## Response to Agency Submissions

Harbourside Shopping Centre Redevelopment

Submitted to Department of Planning, Industry and  
Environment

12 October 2020 | 14657

1 Shadow Projection JUN 0900 9am

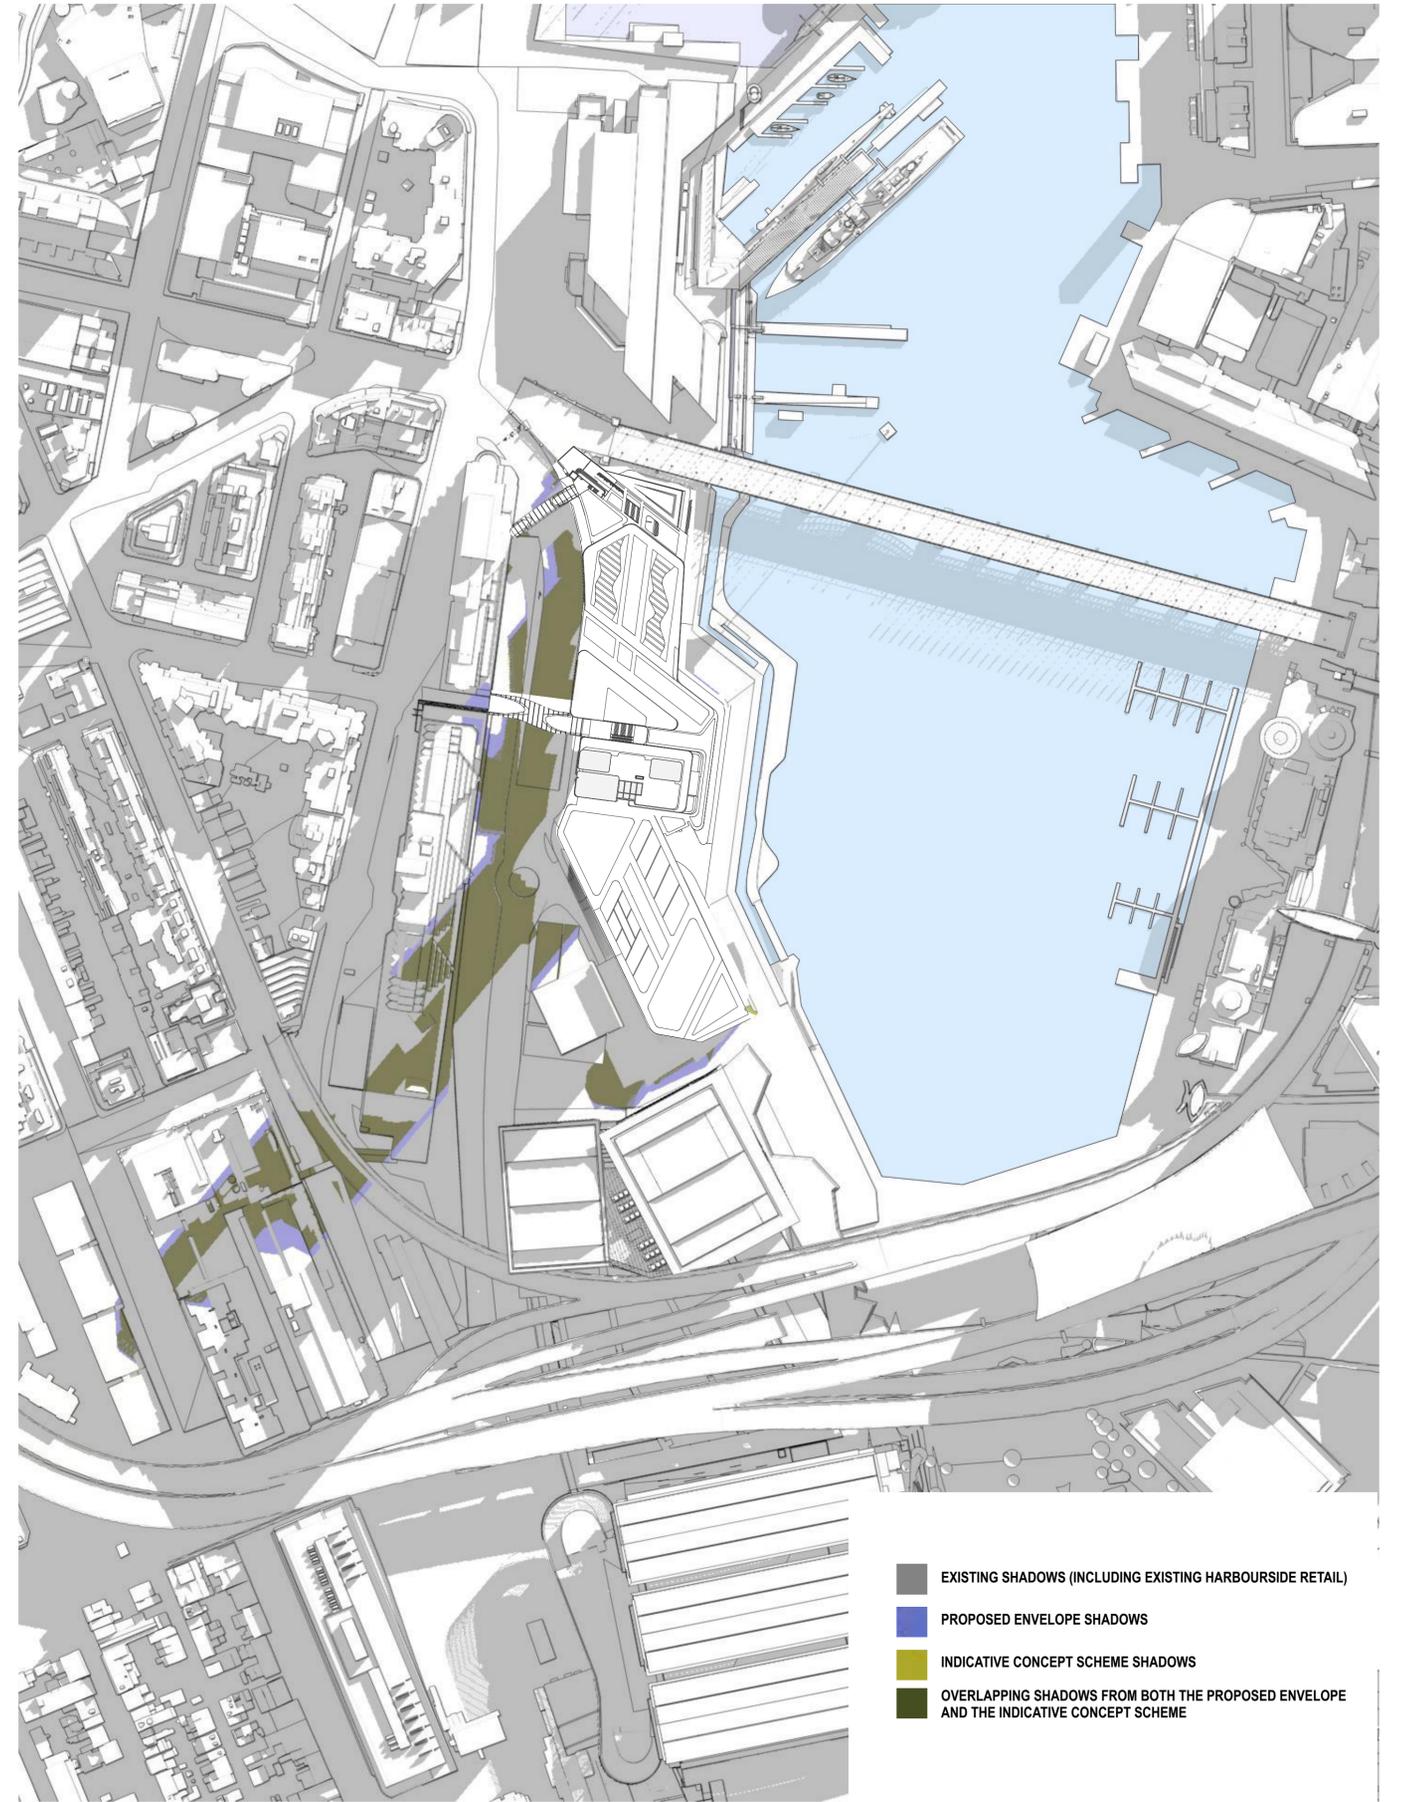
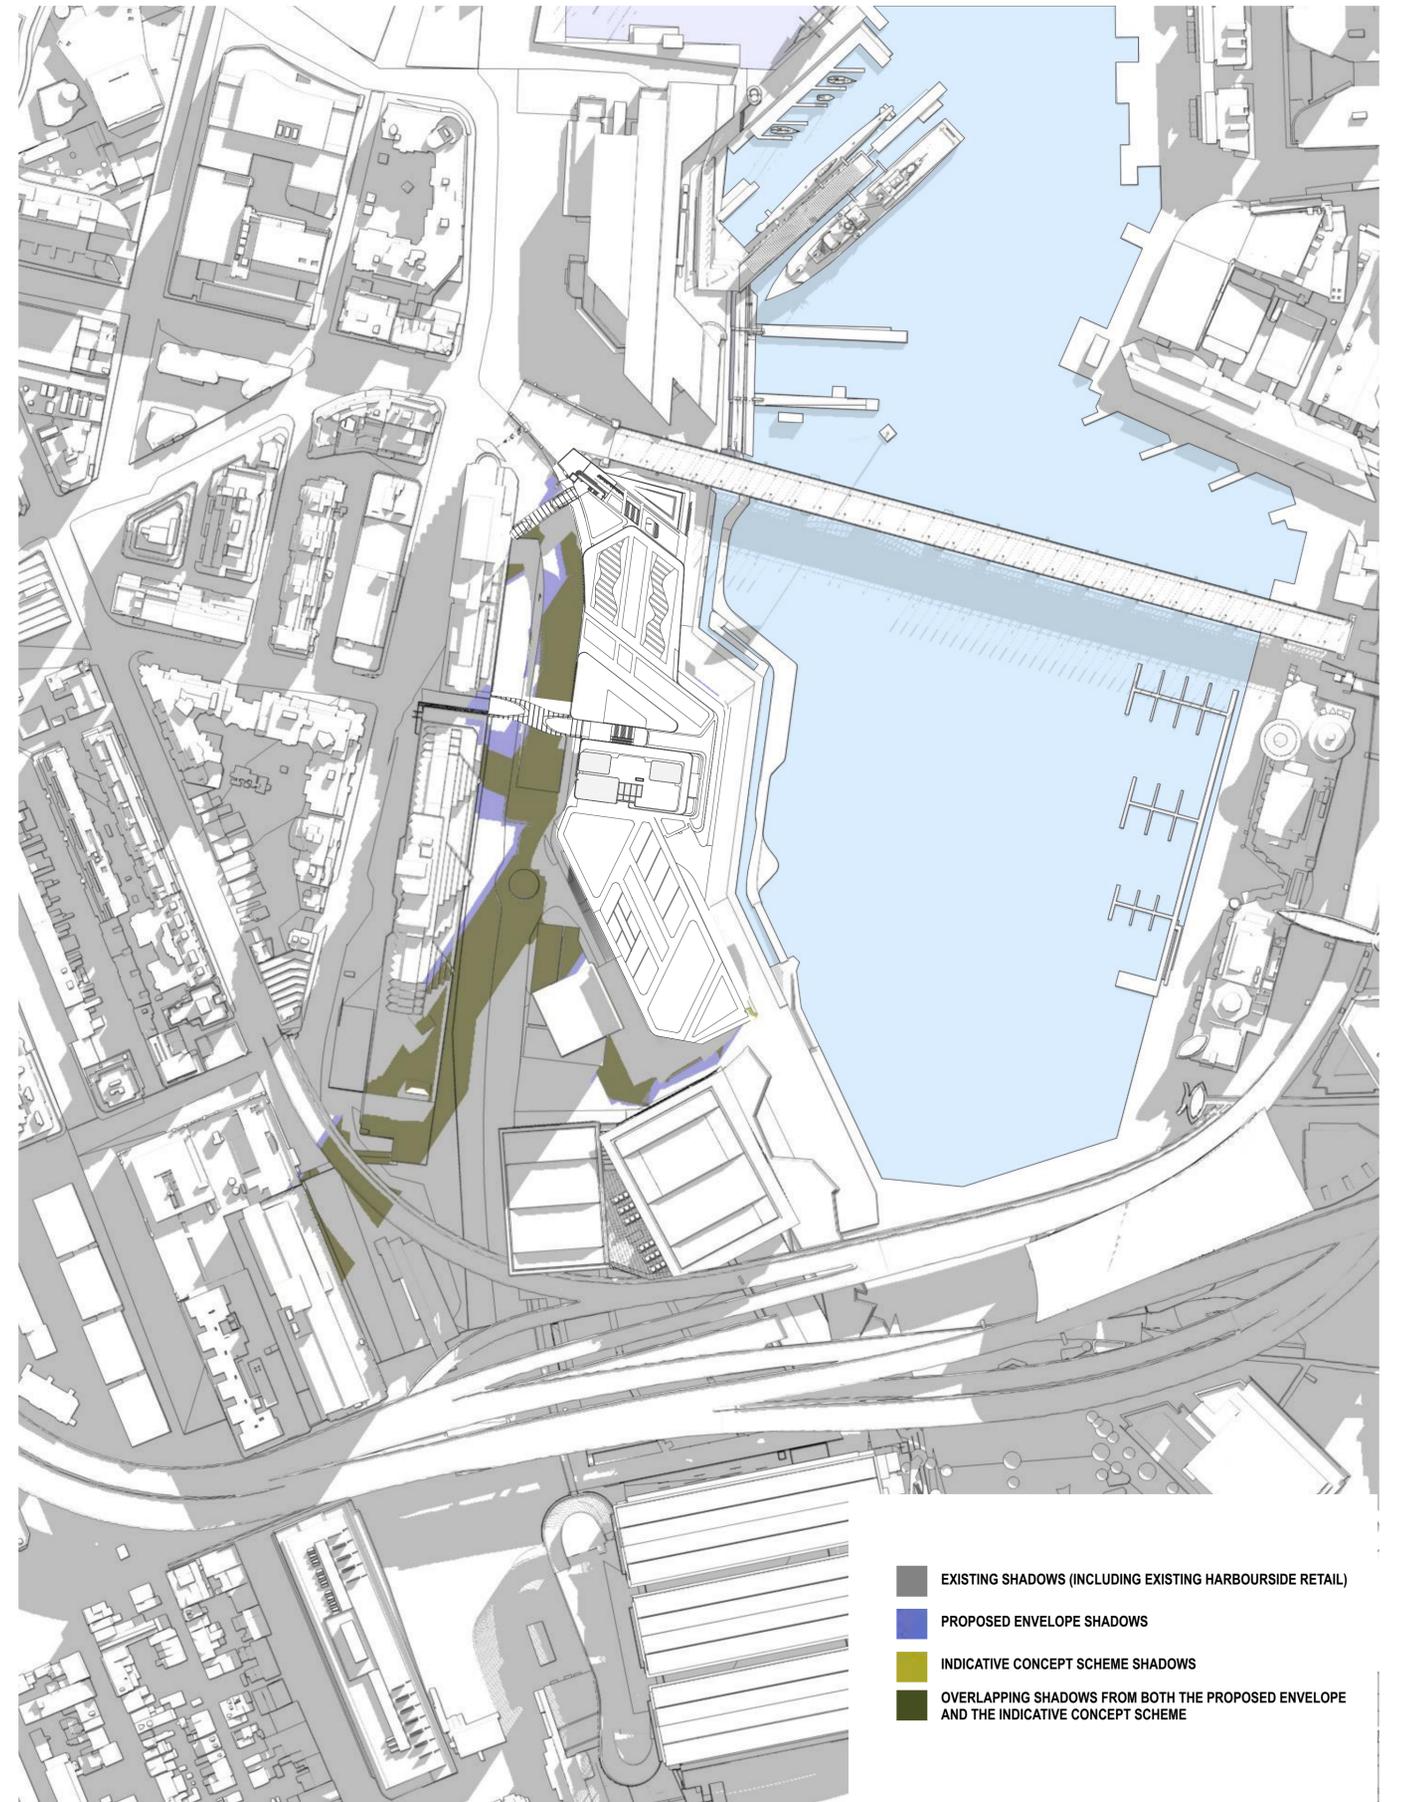
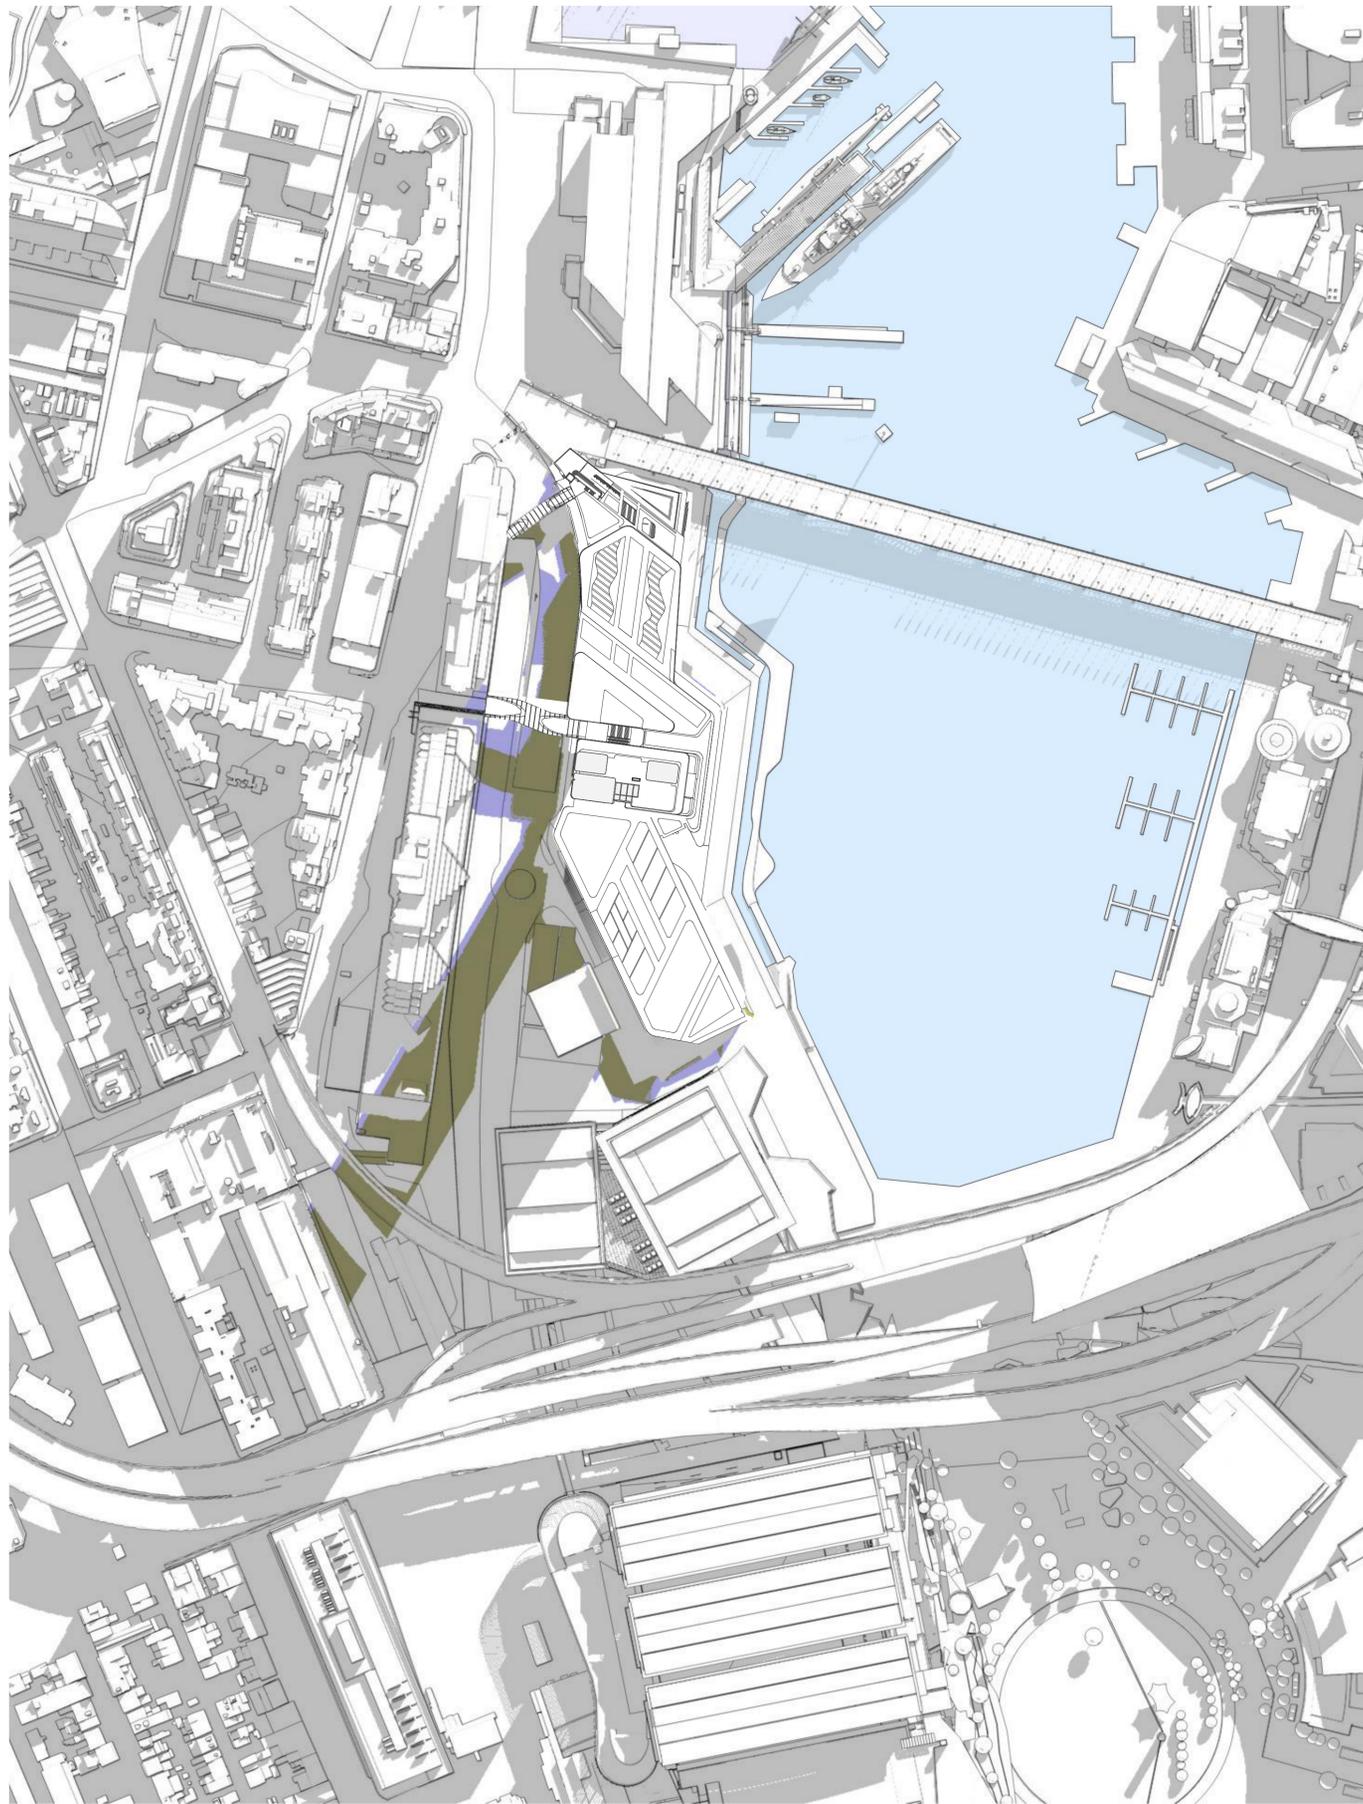
9. Provide a detailed overshadowing analysis of the Darling Harbour foreshore/ promenade in 15-minute intervals.	<ul style="list-style-type: none"> <li>Detailed 15 min interval shadow diagrams have been prepared by fjmt and included within the Architectural Design Report appended to the RTS Report.</li> <li>Refer to RTS Report and Architectural Design Report for detailed discussion and response.</li> </ul>
<u>Private view impacts</u> 10. Provide additional analysis of the view impacts to 50 Murray Street (ONE Darling Harbour) and the Novotel hotel including:  a) identification of levels and units at 50 Murray Street where water view and views to Pyrmont bridge will be affected by the proposal, including additional view analysis assessment against the principles established in <i>Tenacity Consulting v Warringah Council</i> (2004) NSWLEC 140  b) a detailed response to the submission received from ONE Darling Harbour and associated view analysis  c) additional view analysis from Novotel hotel rooms including north-east and east facing rooms at lower, middle and upper levels within the northern and central sections of the building.	<ul style="list-style-type: none"> <li>Refer to RTS Report and updated Visual and View Impact Analysis for detailed discussion and response. Additional view analysis has been undertaken for 50 Murray Street (covering every apartment potentially affected by the proposal) and Novotel as requested.</li> <li>A detailed response to the submissions from One Darling Harbour is also appended to the RTS.</li> </ul>

<p><b>3.5 Overshadowing</b></p> <p>The revised shadow diagrams illustrate that the overshadowing of the foreshore is significant between 12-2pm. Whilst relocating the tower to the centre of site reduces the overshadowing to the foreshore, The City requires updated shadow diagrams at 15-minute intervals to be submitted to determine the degree and percentage of the foreshore promenade affected by the development. This is to ensure that the public realm receives solar access at the highly sought lunchtime hours.</p>	<ul style="list-style-type: none"> <li>• Detailed 15 min interval shadow diagrams have been prepared by fjmt and included within the Architectural Design Report appended to the RTS Report.</li> <li>• Under the proposed development, the public domain located to the east and south of the site and more broadly within Darling Harbour will continue to be provided with direct sunlight throughout the morning period on June 21 (the winter solstice) before shadow resulting from the proposed envelope occurs after midday.</li> <li>• It is noted that there are still vast areas of accessible sunlight available in the Darling Harbour public domain notwithstanding the proposed development, including during the key lunchtime period of 12:00pm to 1:00pm when the general public is most likely to use and appreciate the space.</li> <li>• Overshadowing of the waterfront promenade during the afternoon period on the winter solstice would be expected with any reasonable built form outcome on the site, given the proximity of the promenade on the eastern side of the building form. The proposal also offsets additional overshadowing to the public domain, including through the creation of a new northern Guardian Square (1,500sqm) that will have solar access across the entire day for all periods of the year.</li> <li>• The overshadowing expected to result from the tower envelope is restricted to a small proportion of the overall Darling Harbour public domain and is limited to the western and southern side of the public domain. A significant area of waterfront public domain within and surrounding the site is still within direct sunlight between 1:00pm and 3:00pm on the winter solstice.</li> </ul>
